Please ask for: Ms Iqraa Malik
Email: iqraa.malik@terraquest.co.uk
Telephone: 0121 234 1390
Our Ref: LU/403/21/HH
Your Ref:
Date: 16th December 2021

Application for Planning Permission for Works or Extension to a Dwelling

Development: Conversion of loft to habitable use including the installation of 1 x rear dormer.
Location: 16 Harebell Close Littlehampton BN17 6WE

Site Plan

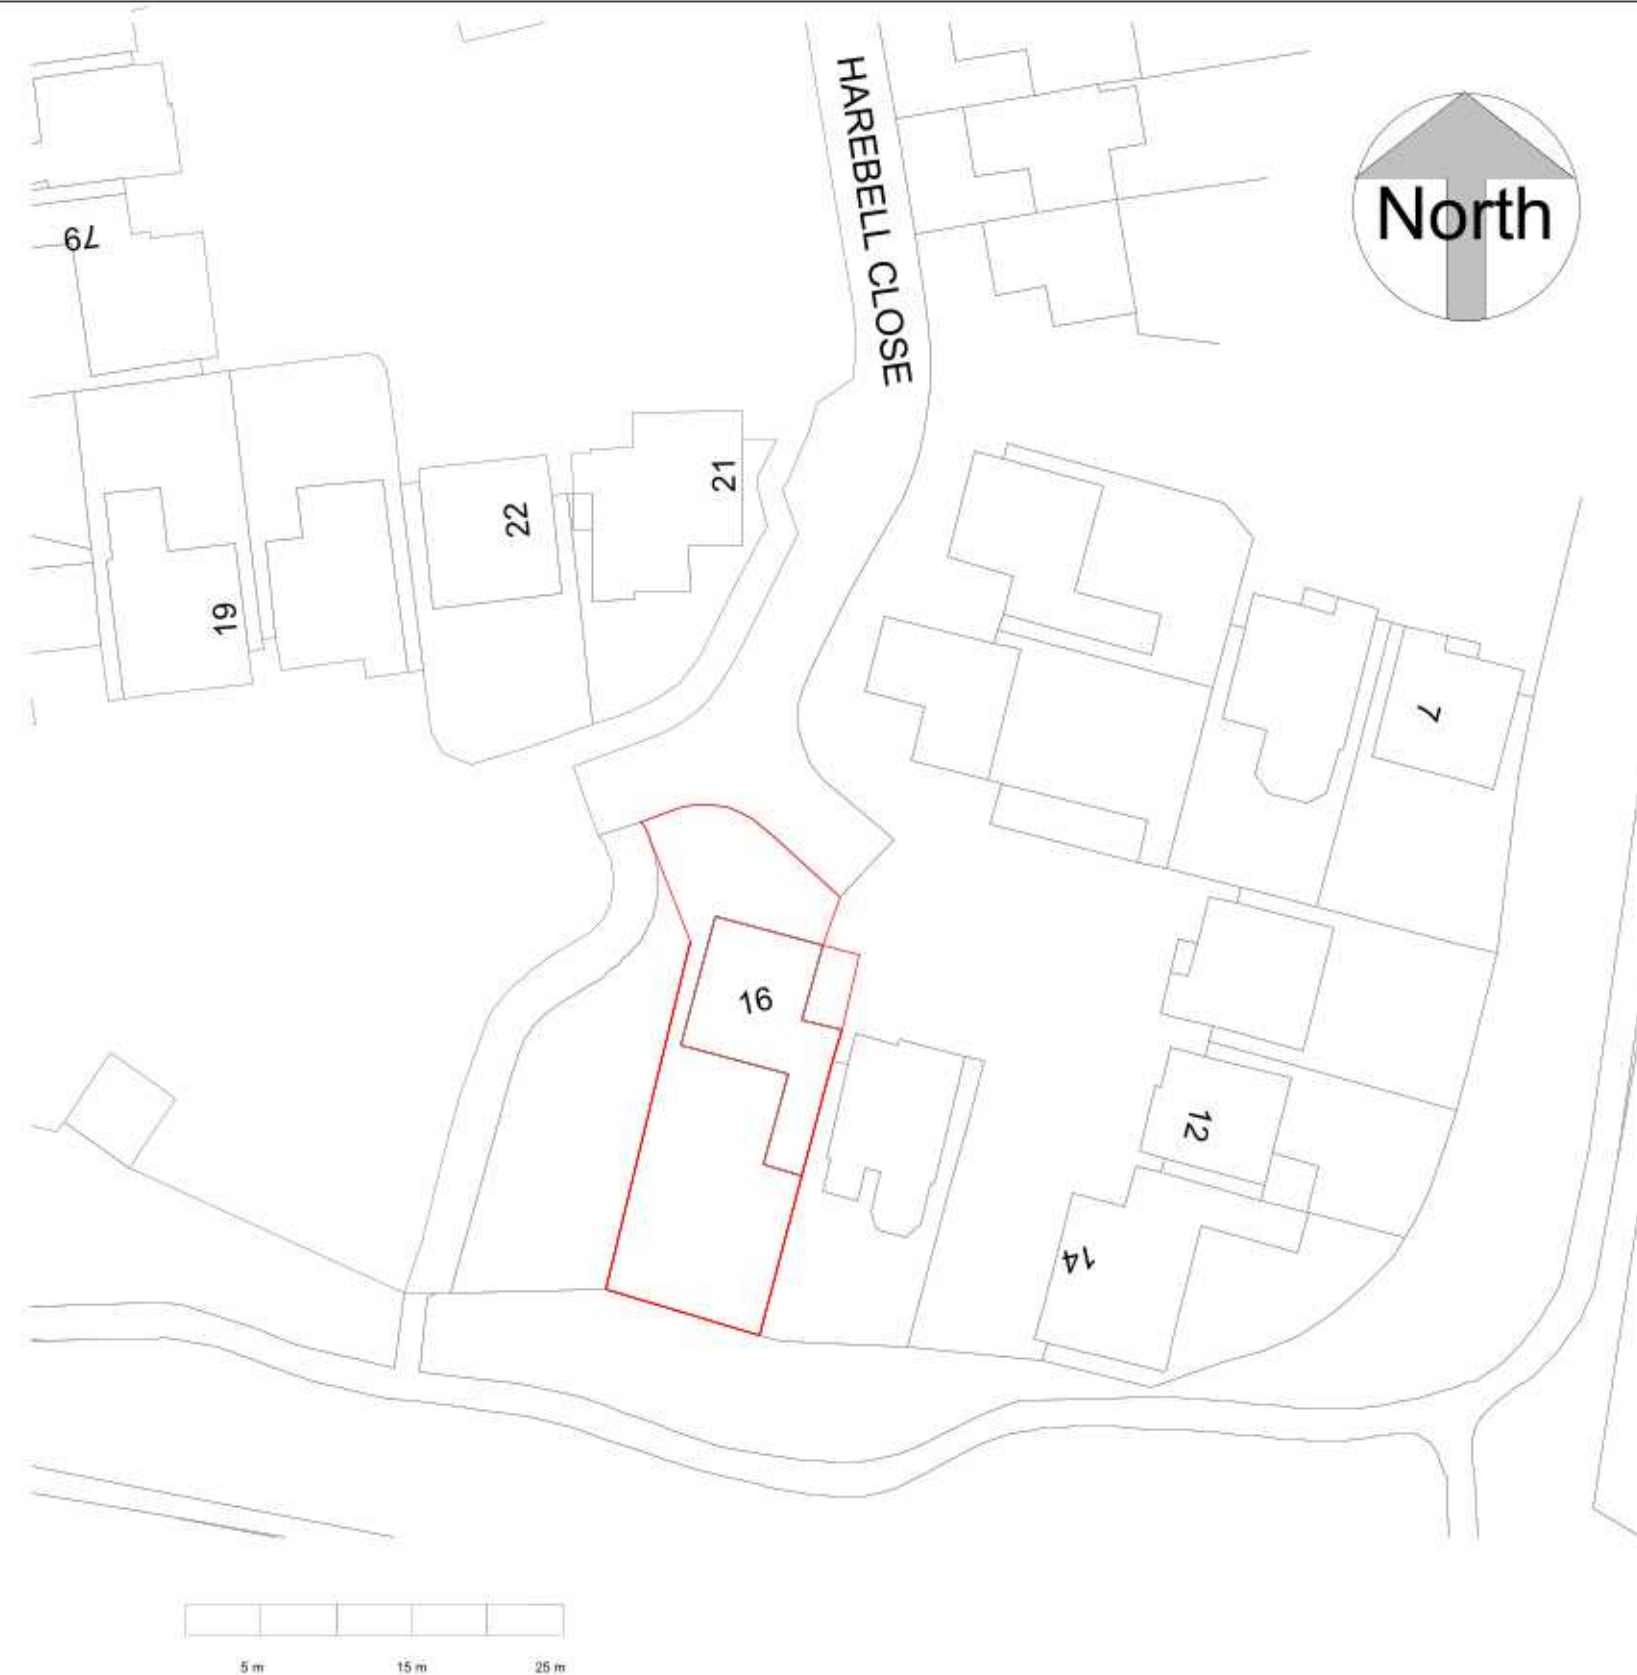
Location and Block Plans

The location and block plans require one solid outline around the site boundary. Please amend. Further details of what must be included on the plan can be found in the Validation Requirements List.
